Arun District Council
Arun Civic Centre
Maltravers Road
Littlehampton
West Sussex BN17 5LF
Planning & Building Control General Enquiries
Tel: (01903) 737756 Fax: (01903) 730442
Dx: 57406 Littlehampton
Minicom: 01903 732765
e-mail: planning@arun.gov.uk
website: www.arun.gov.uk/planning

Application No: R/222/21/HH
Site Address: 42 Pigeonhouse Lane Rustington BN16 2BE
Description of works: Single storey rear extension and hip to gable loft conversion with 2 x dormers following the demolition of existing rear conservatory

Thank you for your internet representation made on 14th October 2021 which has been recorded as an objection with the comments as follows:

:: Proposed South Elevation

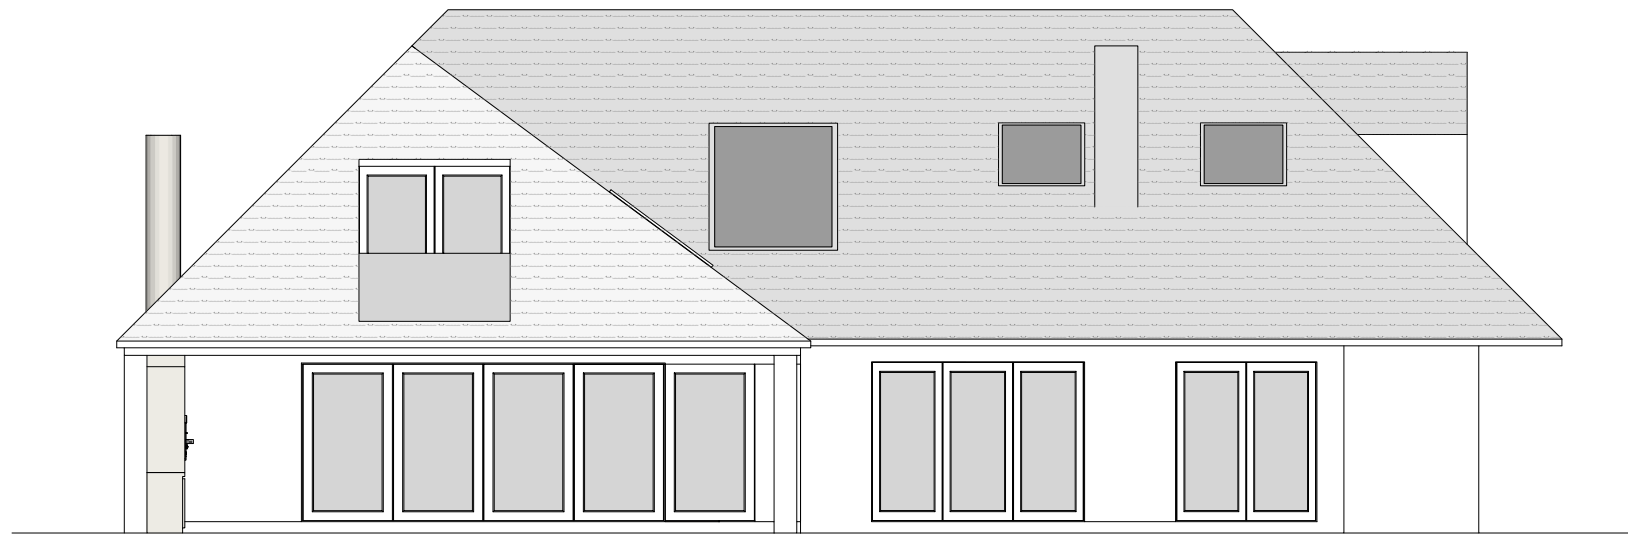
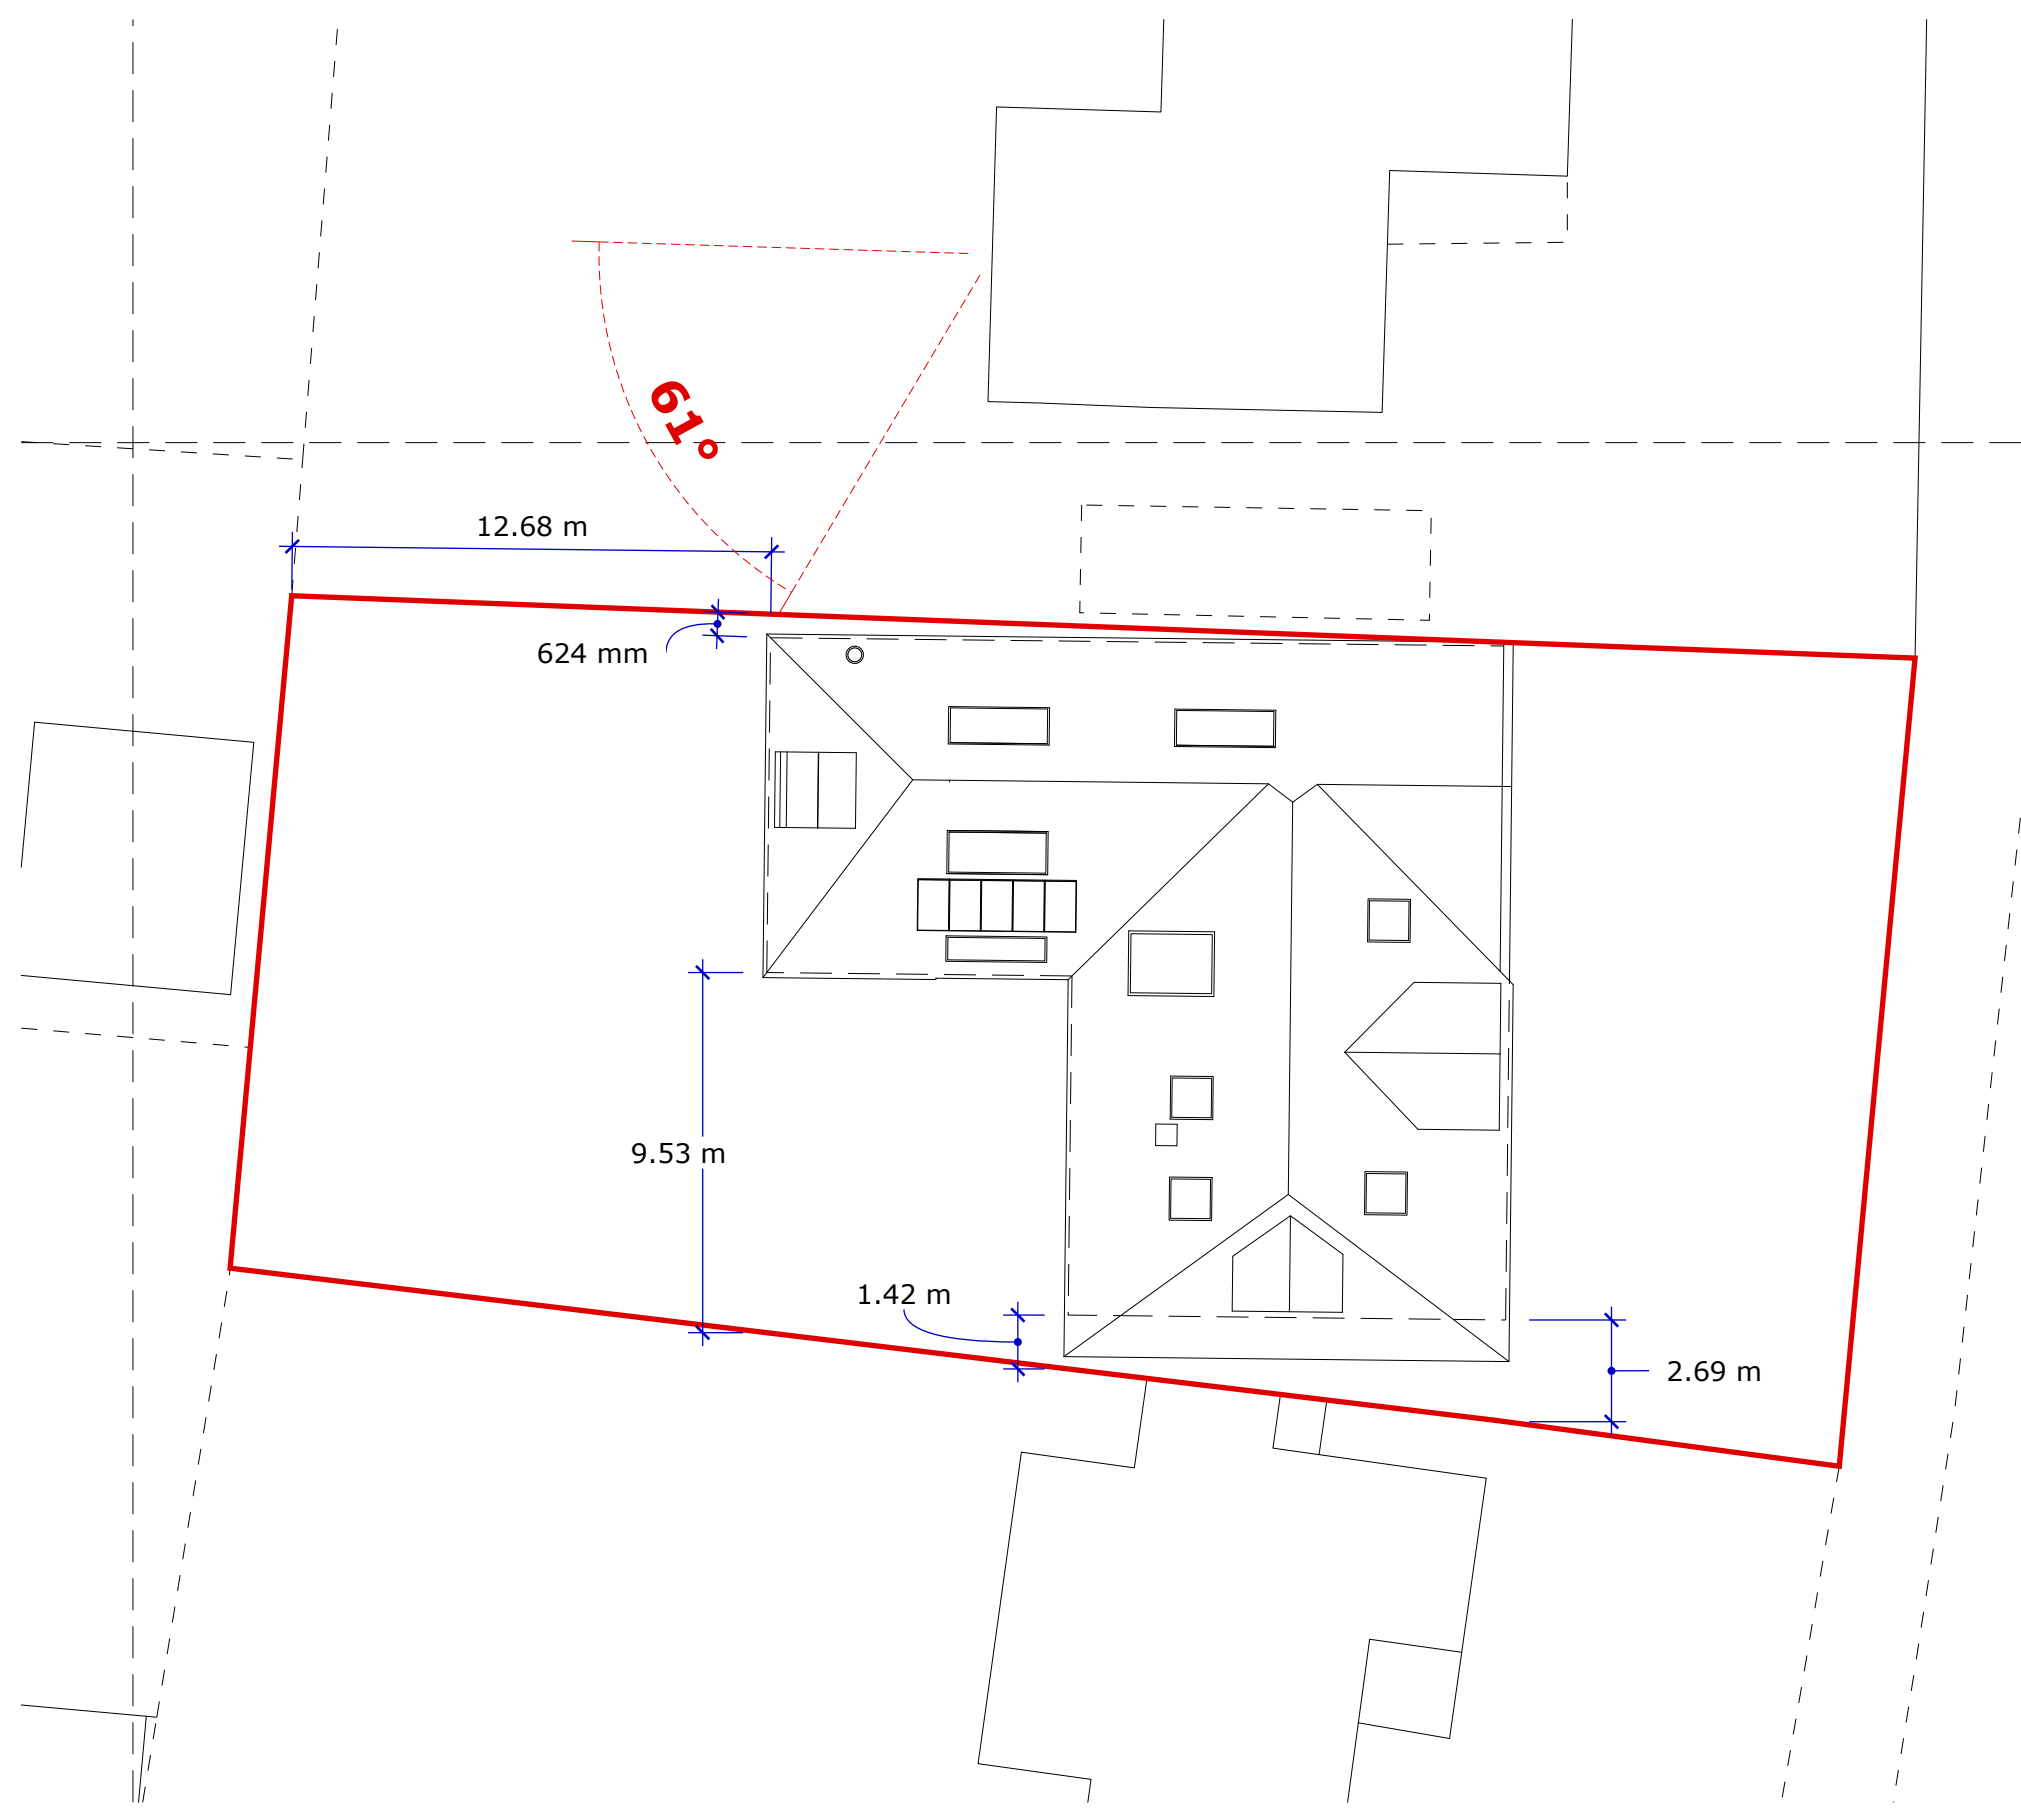
The first floor Dormer on South roof elevation when in isolation is not an issue however when taking into consideration our property to South which has a tiled gabled Dormer currently facing out to the South roof elevation of the applicants property the new Dormer would appear over bearing and disjointed. We would have no objection to a Velux style Roof Window which would in our opinion be more appropriate for a bathroom set within a pitched hipped roof and ultimately be less obtrusive.
